SEALINK Options SUBMISSION

Sea Link Development Consent Order Examination
[Your Reference / Interested Party Number]

1. Purpose of this submission

Scheme: SEA LINK  
 Document Title: KENT CONVERTER SITE OPTION AREAS

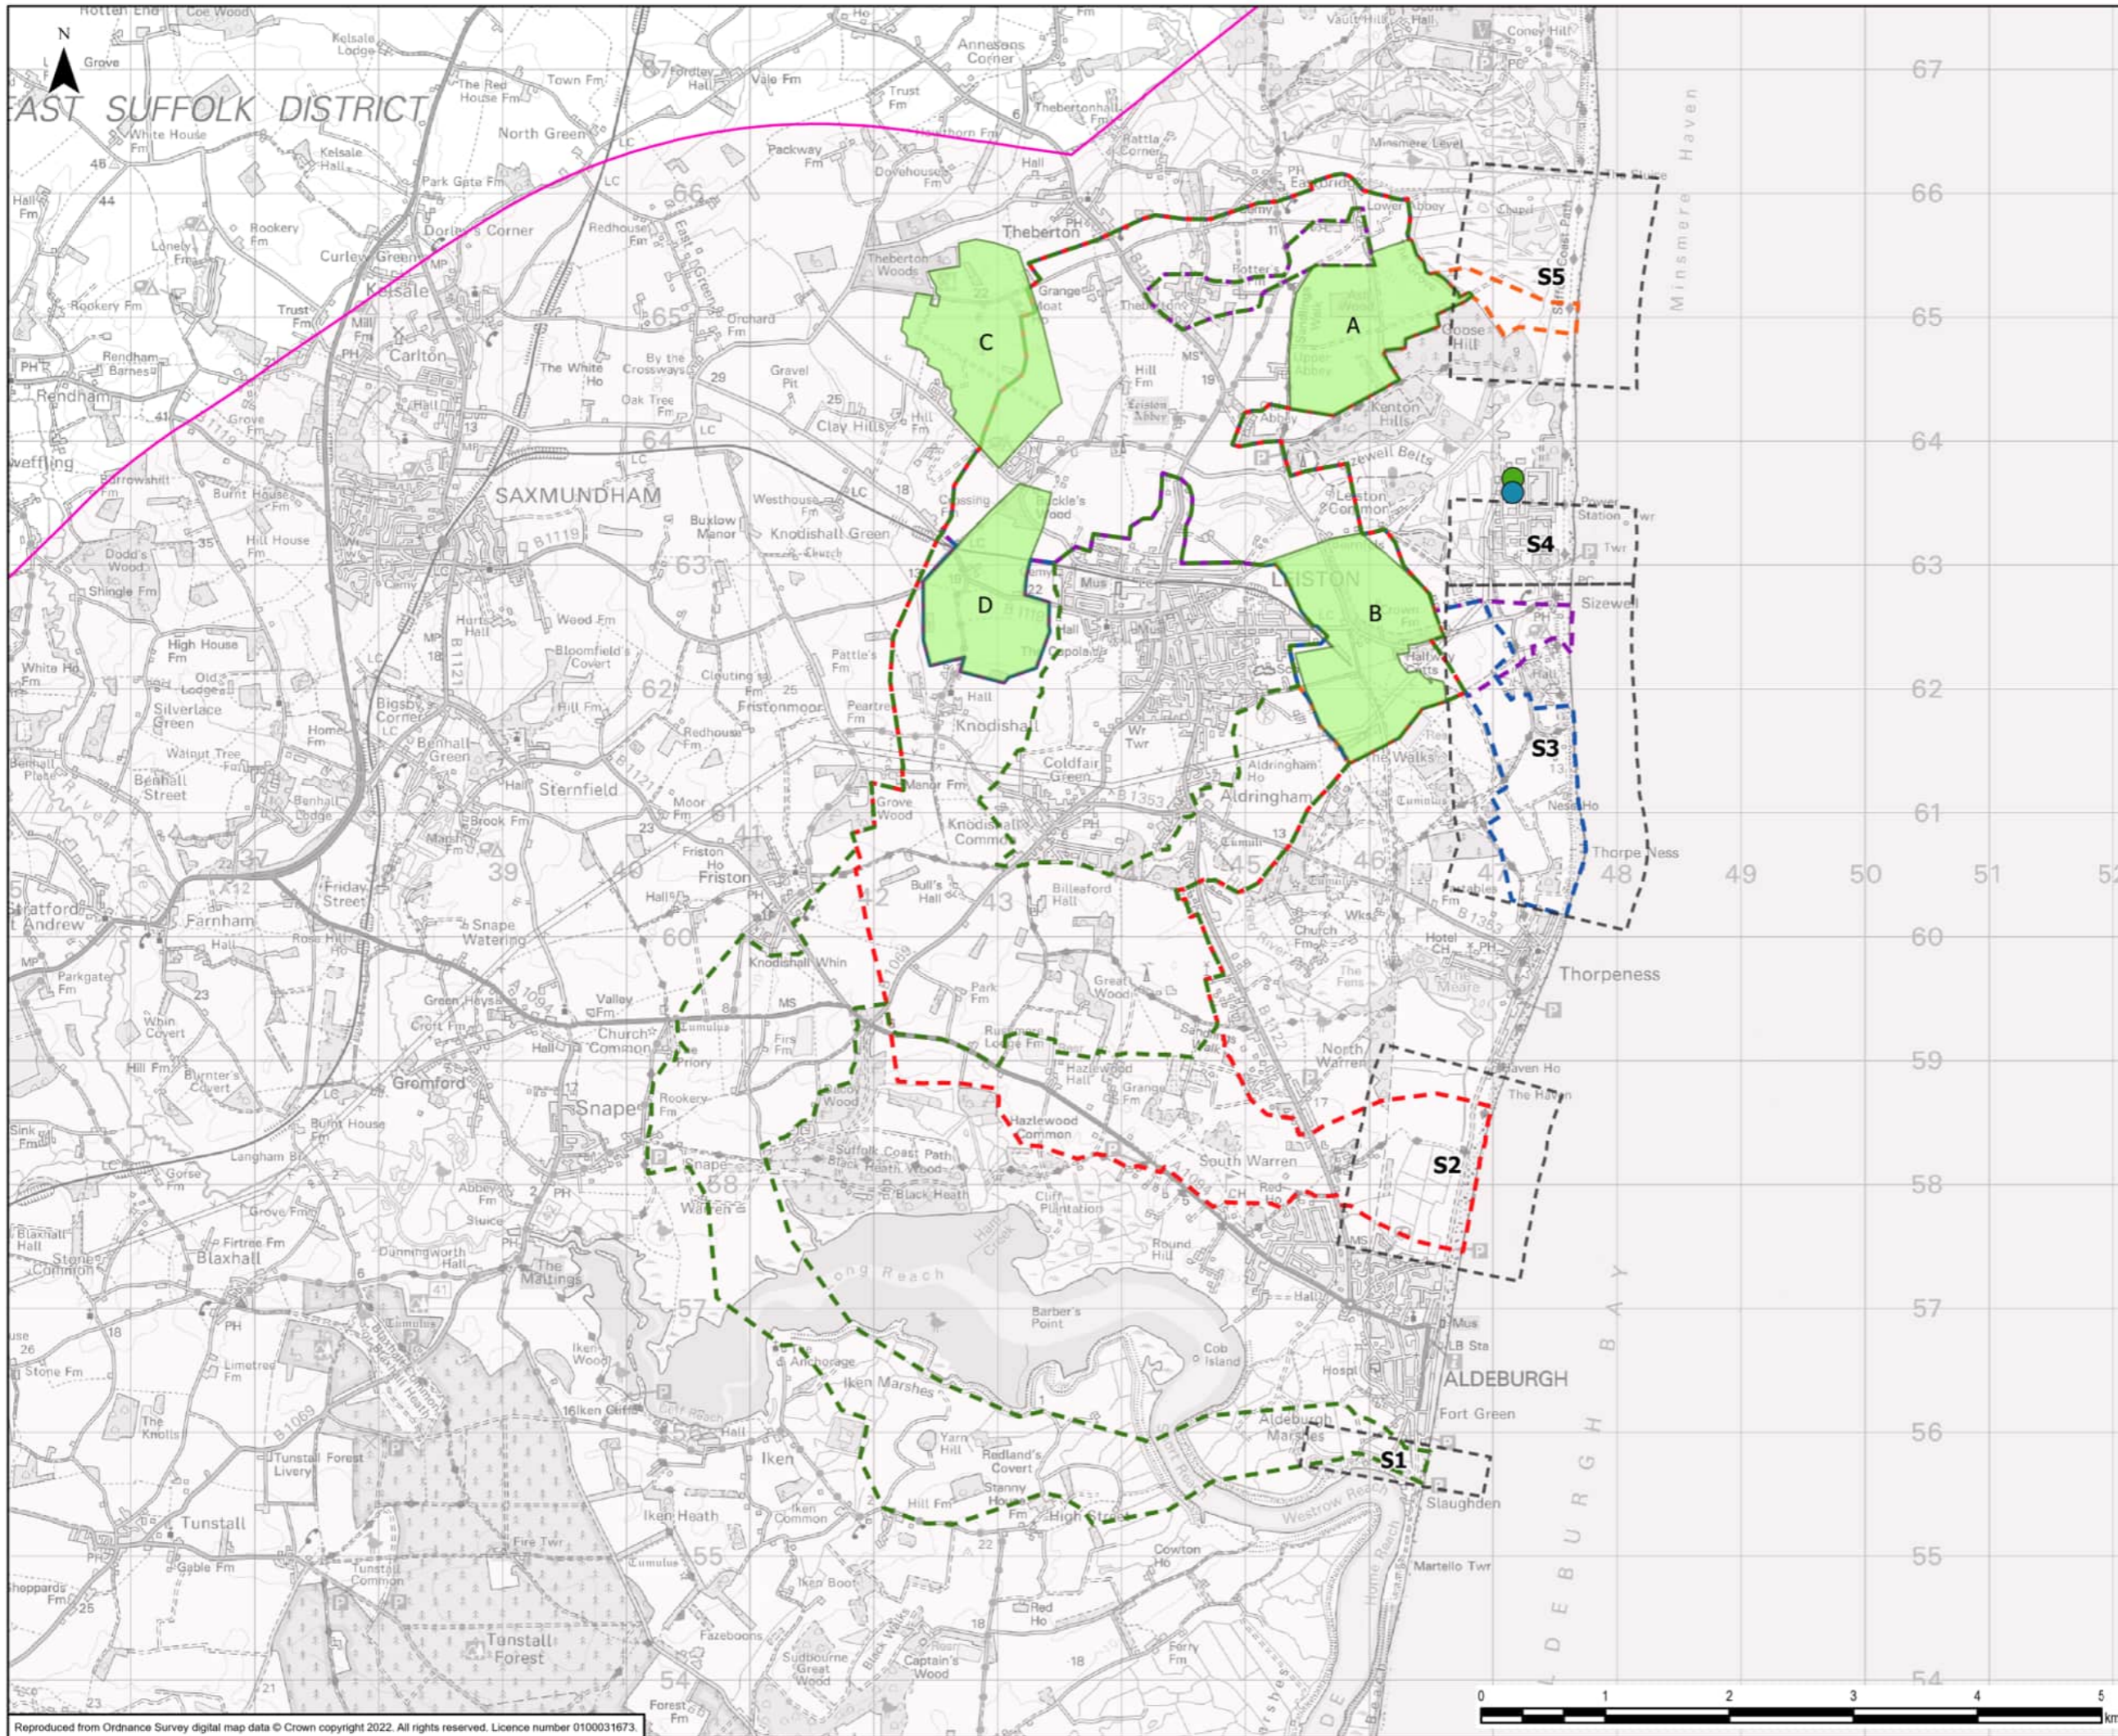
The Applicant's earlier routeing and siting work identified "**Converter Area A – Richborough Energy Park**" as the initially preferred Kent converter location. This reflected:

This represented an **area of search**, not a fixed plot. The examination record does not include a scaled layout showing where within the Energy Park the converter would have been located, nor does it provide a transparent explanation demonstrating why that preference later changed.

Planning permission for the battery installation was granted in September 2024. The examination record does not indicate that the Applicant objected to that development on the basis that it would compromise delivery of Sea Link as nationally significant infrastructure, nor that land was formally safeguarded for Sea Link at that location. This raises a legitimate question as to whether coexistence was considered feasible at that time, or whether Richborough was no longer treated as a required converter site.

Based on publicly available engineering precedents, compact configurations are typically of the order of **3–6 hectares permanent footprint**, broadly comparable to infrastructure already accommodated within Richborough Energy Park. The examination record does not demonstrate whether such configurations were evaluated when considering Richborough feasibility.

Accordingly, it remains unclear whether any identified constraints at Richborough were **absolute site limitations** or dependent upon the assumed design envelope.

The current record does not provide a scaled constraints plan demonstrating:

- where the converter would have been located within Richborough,
- the effect of existing infrastructure, easements, and land use,
- whether a reduced-footprint configuration could be accommodated,
- whether constraints are absolute or design-dependent.

- A scaled layout showing available and sterilised land within Richborough Energy Park,
- An overlay of a reduced-footprint converter configuration,
- A table identifying which constraints are absolute and which are design-dependent.

1. Where within Richborough Energy Park the converter was envisaged during earlier studies.
2. Whether coexistence with the battery installation was assessed and how this affected feasibility.
3. Whether reduced-footprint / compact converter configurations were evaluated.
4. Whether any constraints at Richborough are absolute or design-dependent.
5. Whether programme duration is sensitive to converter configuration and site selection.
6. Whether a transparent comparative assessment of environmental and water-environment impacts has been undertaken between alternative siting and design options.
